**Planning Department
Transportation Development Services**

February 12, 2015

**Re: Sandia Area Federal Credit Union, 11301 Montgomery Blvd. NE
Traffic Circulation Layout
Plan Dated 02-04-15 (F22-D002)**

**TRAFFIC
CIRCULATION
LAYOUT**

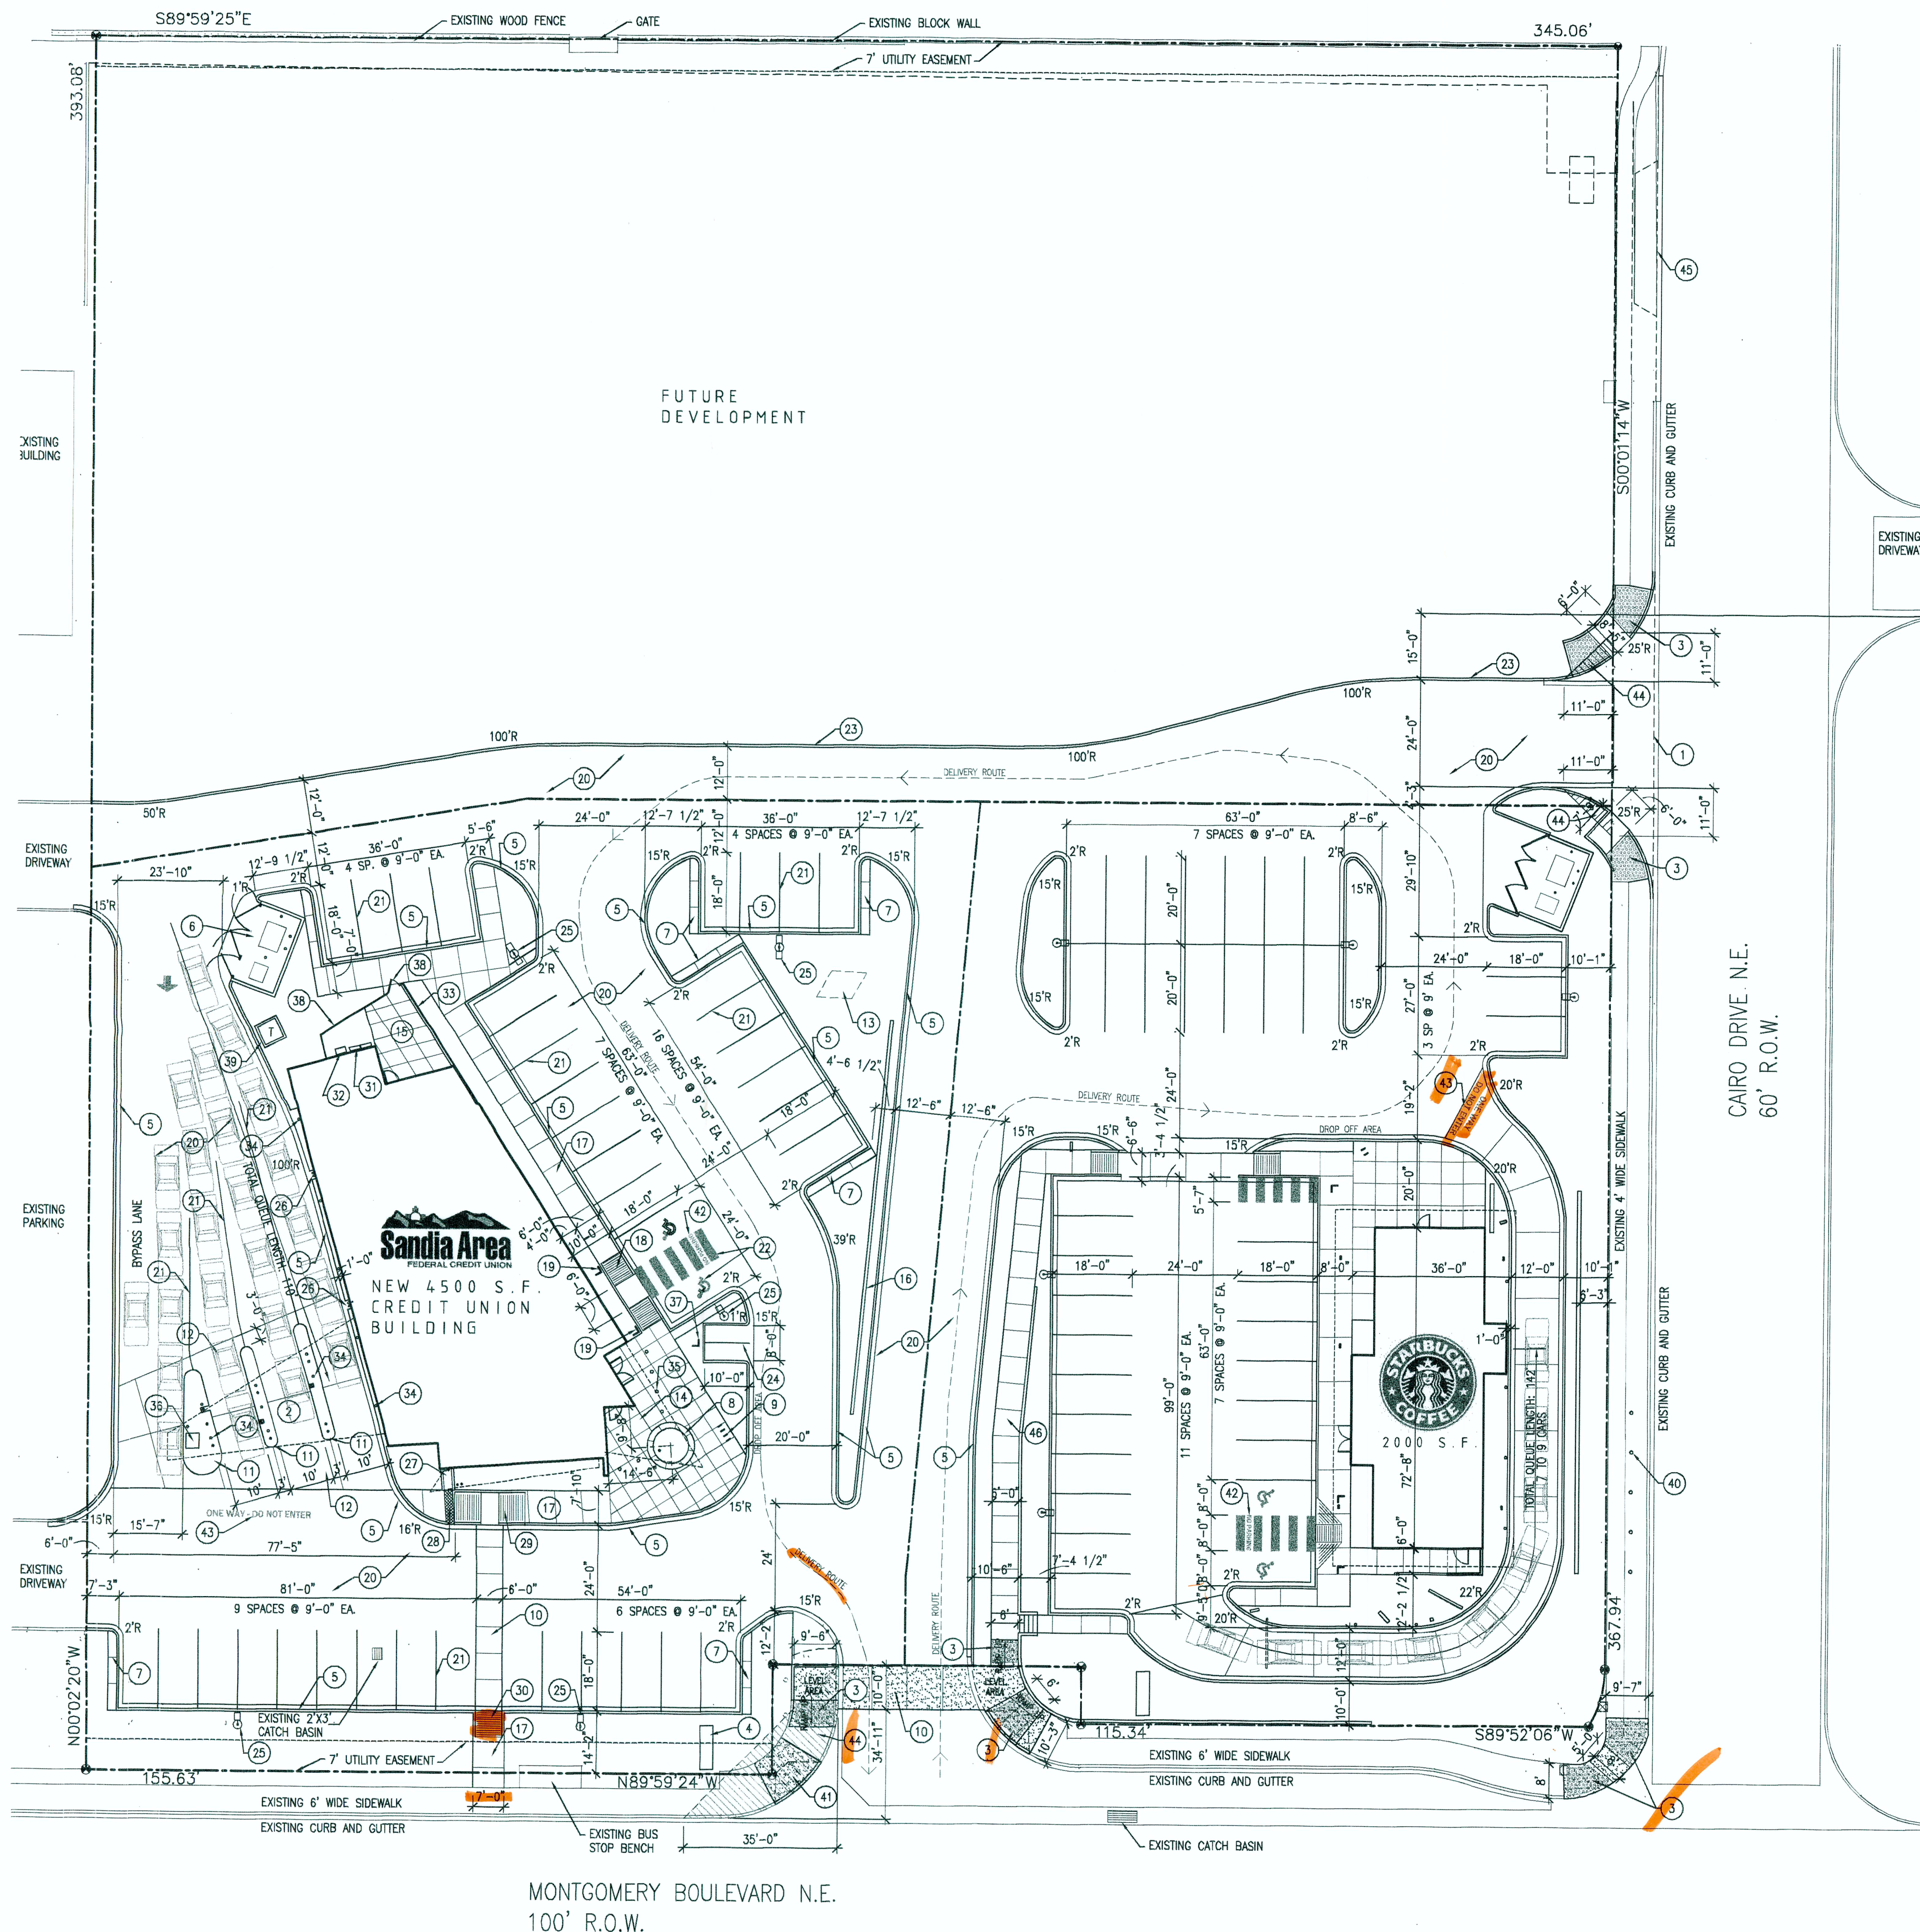
1. The proposed development looks like it may meet the threshold for a Traffic Impact Study based upon the combined square footage of the Sandia Area Credit Union building and the Starbucks. Provide a trip generation.

2. Please provide a zone atlas number for the vicinity map.
3. For the next submittal, provide the details for the curb, pavement section for the parking lot, handicapped ramp, and handicapped parking spot signage.

4. Identify adjacent street widths and right-of-way widths for Montgomery Boulevard and Cairo Drive. List the existing sidewalk widths for both streets.

5. Remove and replace the ramp on the northwest corner of the Cairo Drive/Montgomery Boulevard intersection to comply with more current ADA standards, and include the truncated domes. Design the ramp so that pedestrian traffic can easily access it across Cairo Drive and across Montgomery Boulevard. Construct the ramp around the existing mastarm using header curb so that you will not have to relocate it.

6. Remove the handicapped parking spot signage within the Cairo Drive right-of-way that is being unused.
7. Show where new on-site curb begins and ends. Differentiate between existing and new curb. It would be easier to show a different legend for the existing curb. Replace the existing ramps at the access off of Montgomery Boulevard to match current ADA standards and include the truncated domes.

8. For Keyed Note 3, call out the necessary COA Standard Dwg. Number. Call out the necessary COA Standard Dwg. Numbers for any work within COA right-of-way as applicable. Be sure to include truncated domes for the curb ramps at the access off of Cairo Drive.

9. For curb called out for Keyed Note 23, show all curb radii. Show the 24-foot dimension width for the parking aisle on the north side of the parking lot east of the main parking aisle off of Montgomery Boulevard. Label curb radii for the access off of Montgomery Boulevard, even if this is meant to be existing and left alone.

10. List length of queues for both the credit union and the Starbucks. Show both the overall length and how many cars can be accounted for.
11. For the credit union, show widths of aisles in between the concrete islands called out in Note 11. Also, show striping for delineation between these aisles north of the islands for a certain distance until the drive necks down.

12. Provide a 6-foot wide ADA accessible connection from Starbucks to the existing street right-of-way. It is required to have a 6-foot ADA accessible pathway from the public right-of-way to the building entrances.

13. Include a minimum width of 8 feet wide for both van access aisles. The ADA van accessible sign must have the required language per 66-7-352.4C NMSA 1978 **"Violators Are Subject to a Fine and/or Towing."** Include an accessible signage detail for the next submittal showing this language.

14. The words **"NO PARKING"** for each of the van accessible aisles should be at least one foot high and at least two inches wide. Call out these dimensions within a keyed note.

15. A design delivery vehicle route needs to be shown from the public right-of-way and through the parking lot for the two new facilities.
16. "Do Not Enter" signage is required at the end of the driving aisles for the drive-thrus at both on-site facilities.

17. The wheelchair ramp called out by Keyed Note 29 needs to have a minimum 4 foot by 4 foot level surface landing at the top of the ramp for wheelchair turning.

18. Please provide a sight distance exhibit for the drive onto Montgomery Blvd. (see the *Development Process Manual, Chapter 23, Section 3, Page 23-28, Part D.5 Intersection Sight Distance*).

19. Please add the following note to this clear sight triangle: "Landscaping and signage will not interfere with clear sight requirements. Therefore, signs, walls, trees, and shrubbery between 3 and 8 feet tall (as measured from the gutter pan) will not be acceptable in this area."

20. For the drive on to Cairo Drive, provide a mini clear sight triangle as per Page 23-74 of the Development Process Manual. For this location, also add the following note to this clear sight triangle: "Landscaping and signage will not interfere with clear sight requirements. Therefore, signs, walls, trees, and shrubbery between 3 and 8 feet tall (as measured from the gutter pan) will not be acceptable in this area."
21. For required spaces of between 36 to 50 spaces, 3 accessible parking spaces are required (NMBC Table 1106.1). Therefore, a total of 3 spaces would be required for Starbucks, and 3 spaces would be required for the credit union.
22. Please submit two copies of the Traffic Circulation Layout for the next submittal.
